CITY OF ALBUQUERQUE

March 2, 2006

Re: PMG CONSTITUTION PARKING LOT A, (L-15/D5)
8300 Constitution Avenue NE
Paving, Grading & SO-19 Plan
Engineer's Stamp, 10/27/2005
Certification Engineer's Stamp 02/22/2006

Grading Plan
1"=20'

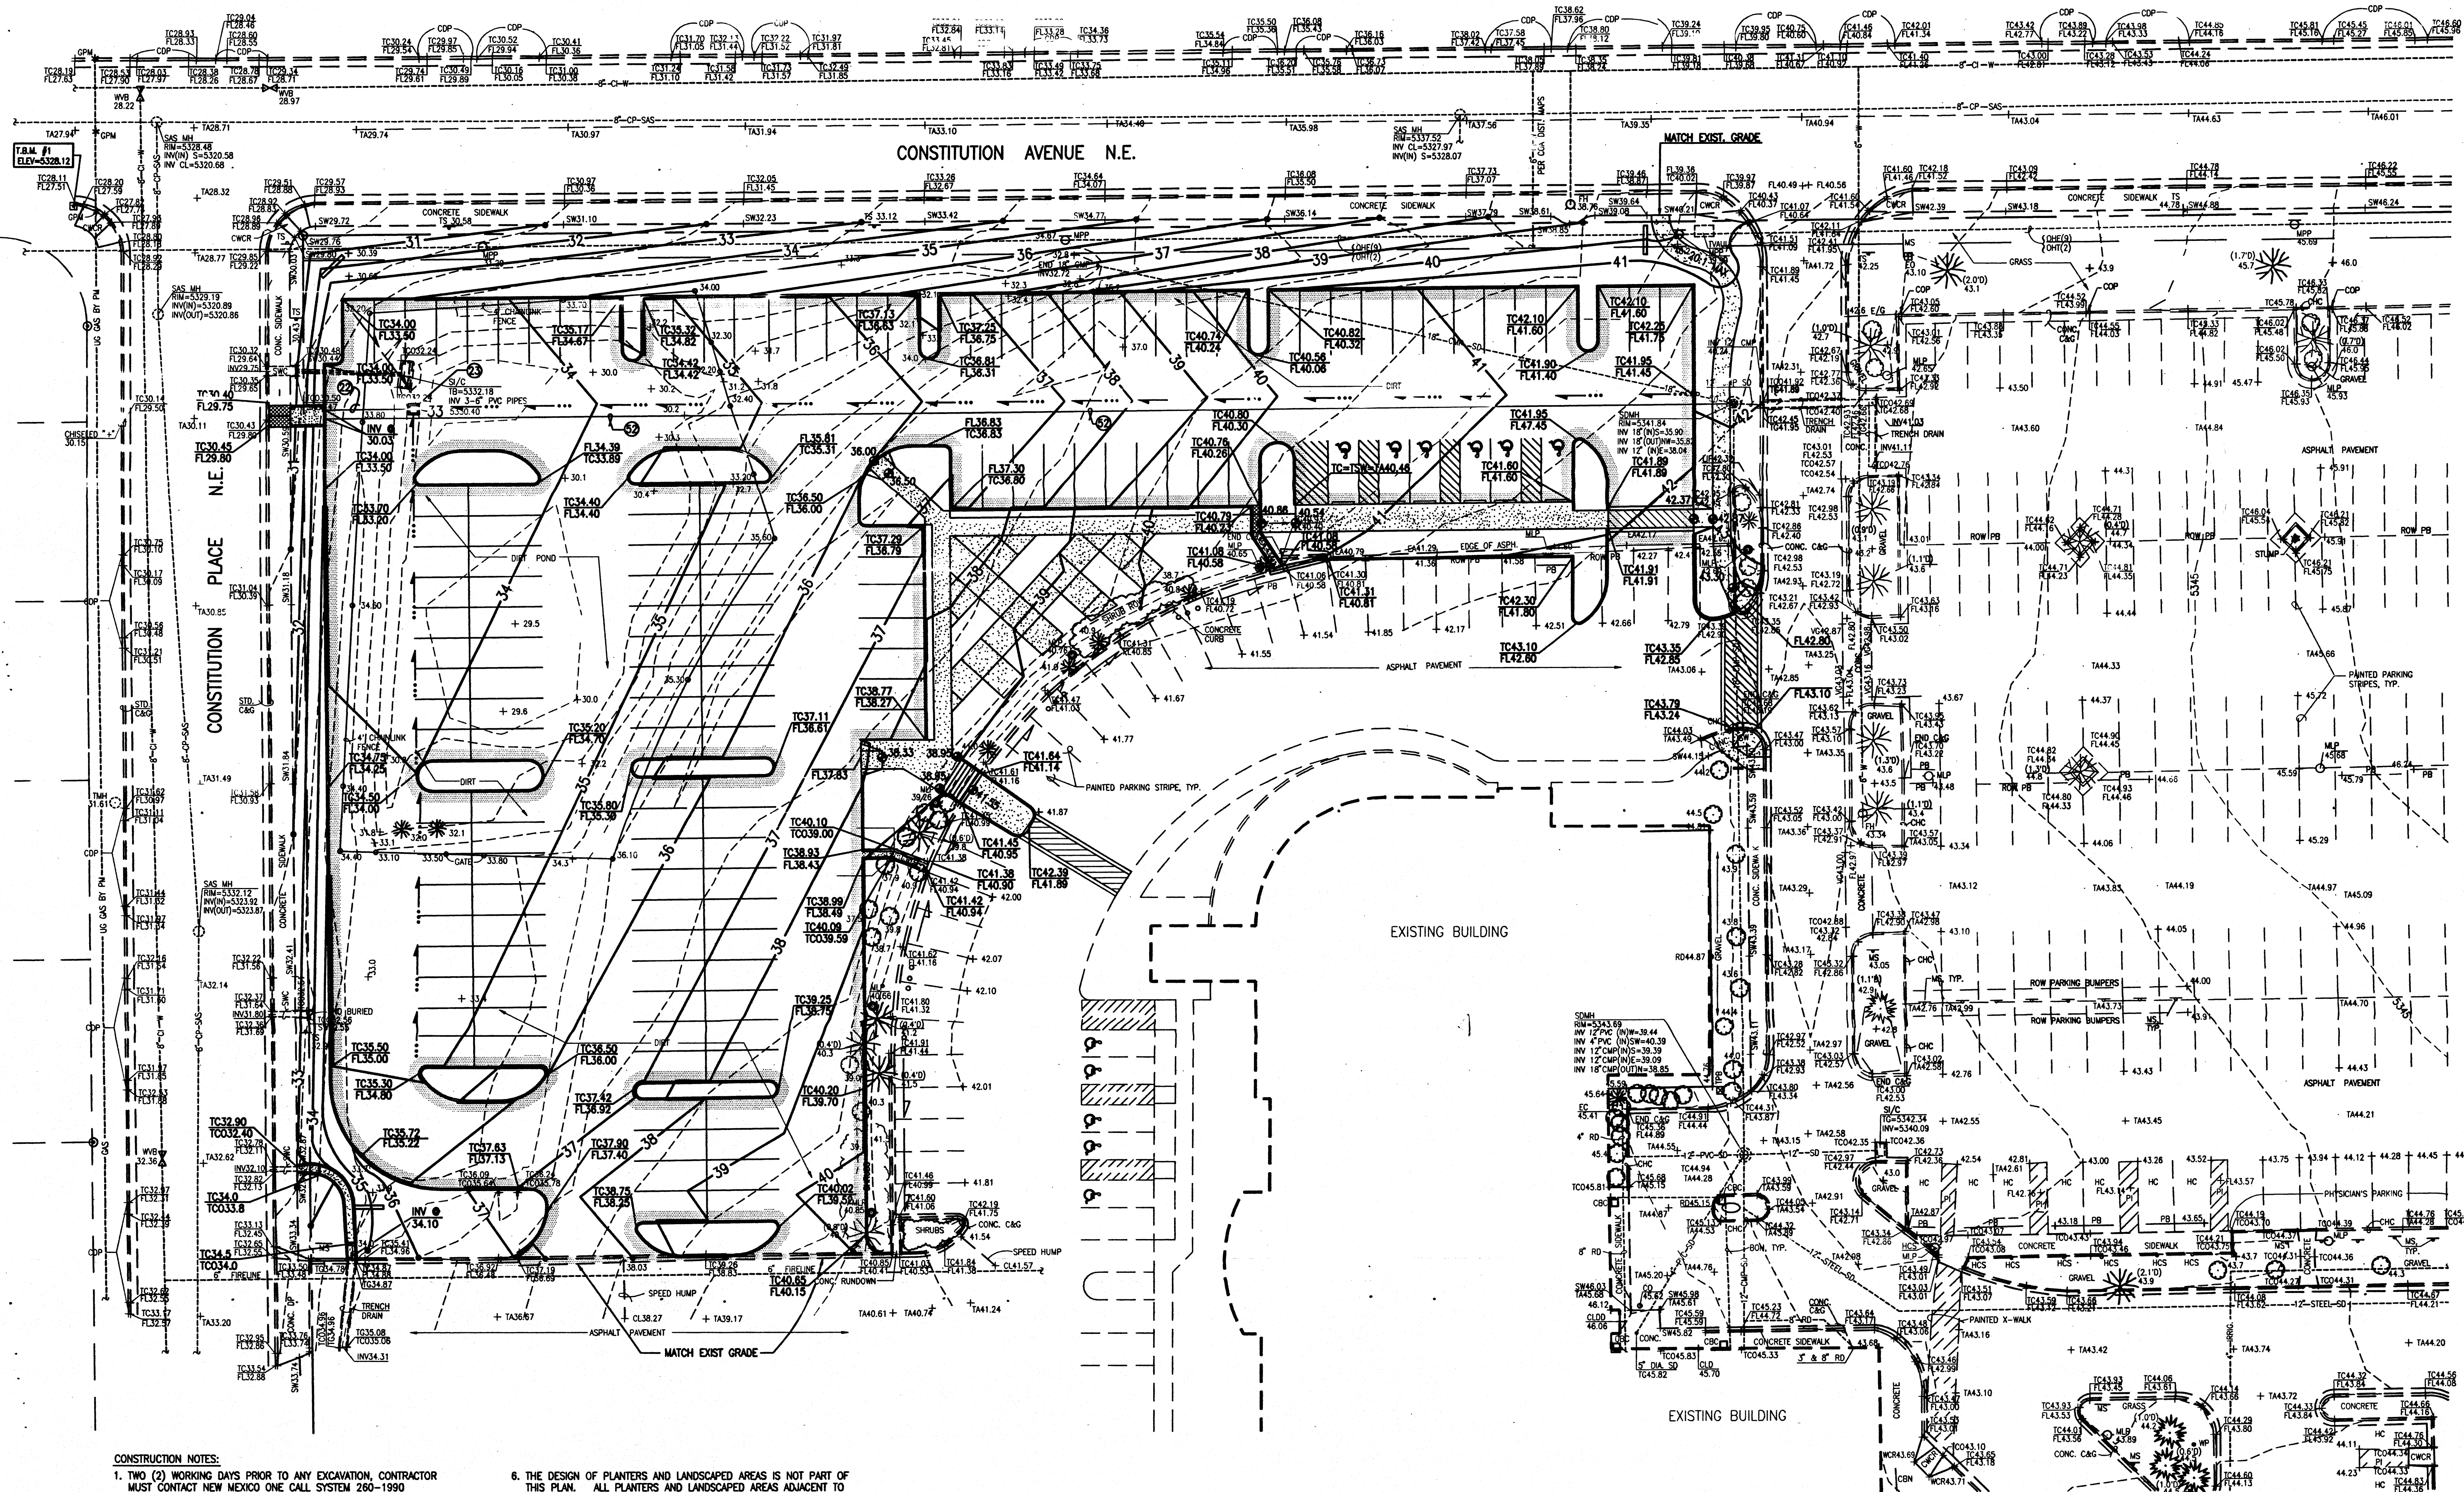
- Call out width of sidewalk culverts and reference to details.
- Provide details for proposed CMP storm drain outlet structure.
- What is going to happen with the existing storm drain and sidewalk culverts that are no longer used?

- CALL OUT SIDEWALK CULVERTS AND REFERENCE DETAIL AND WIDTHS
- PROVIDE DETAIL FOR ~~gap~~ PROPOSED CMP STORM DRAIN OUTLET
- REMOVAL OF EXISTING SIDEWALK CULVERTS AND STORM DRAIN
